THE THURROCK FLEXIBLE GENERATION PLANT DEVELOPMENT CONSENT ORDER

Written Representations submitted on behalf of the Port of London Authority

PINS Reference Number	EN010092
Interested Party Reference Number	20025539
Document Ref.	PLA 4
Author	Winckworth Sherwood LLP
Date	23 March 2021

Legend

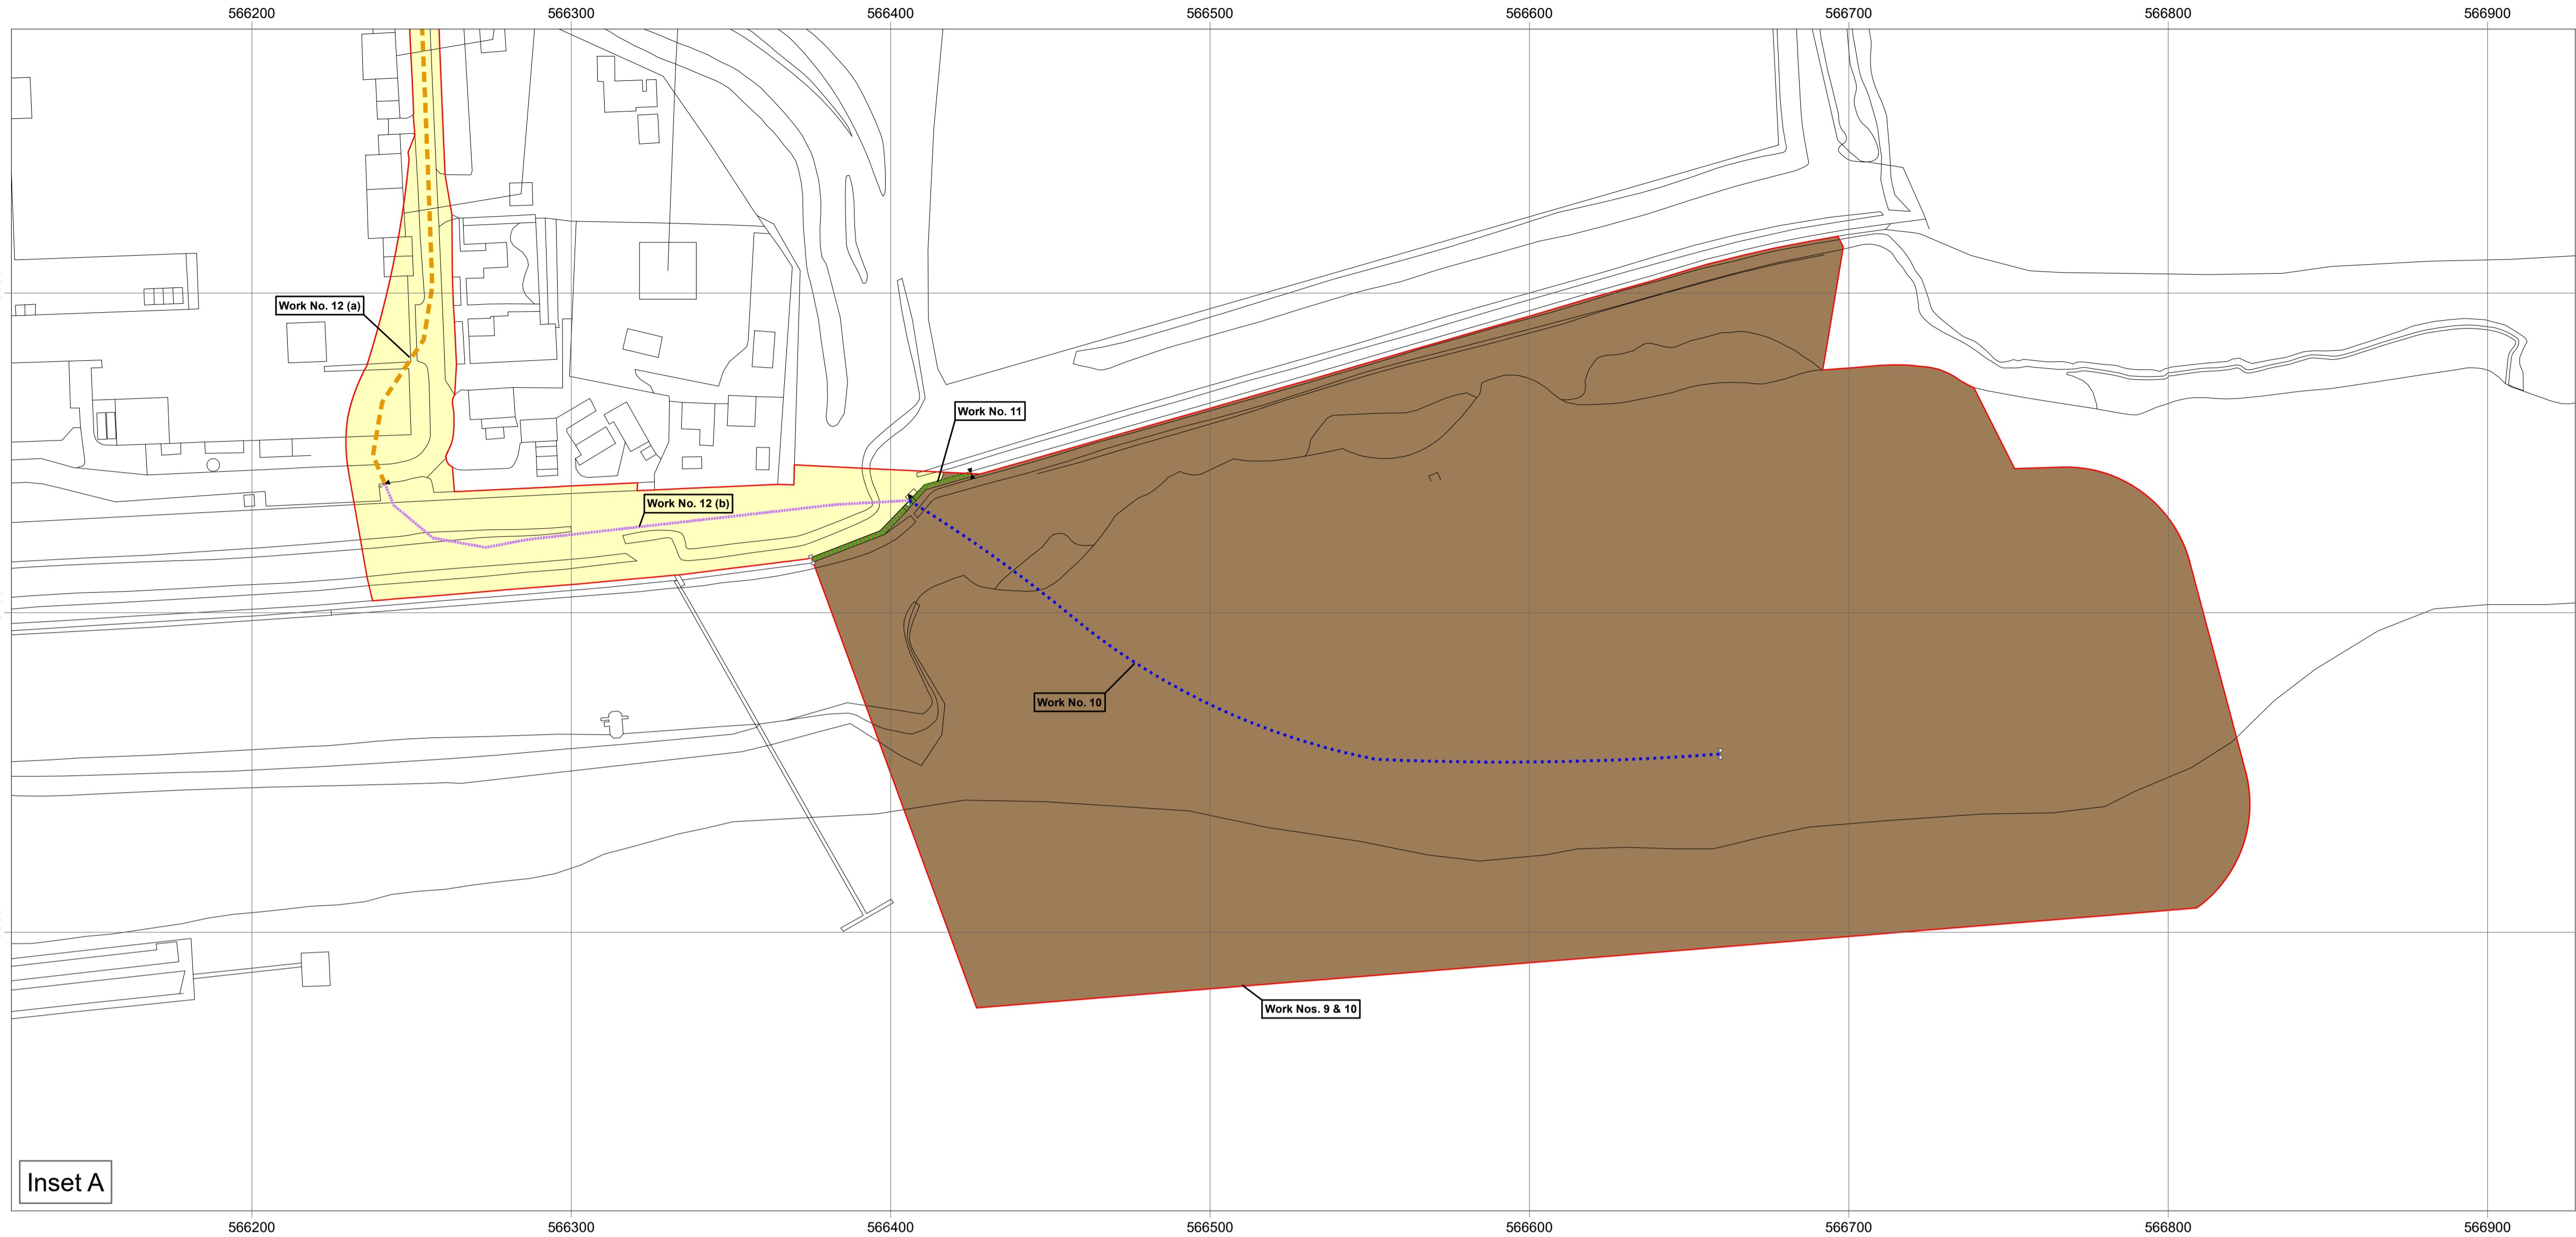
- 4.4 The PLA was concerned to see that there was no reduction in the Limits of Deviation of Work no.10 as part of the change request submitted to withdraw the saltmarsh enhancement proposal. It is understood that TPL does now intend to submit a revised Works Plan with a reduced limit and the PLA was sent draft Rev 3 of sheet 6 on 18 February 2021. If that Plan is submitted to the Examination, and subject to adequate drafting being included in the DCO to secure the causeway design, the PLA is content with the Limit of Deviation for Work no.10.
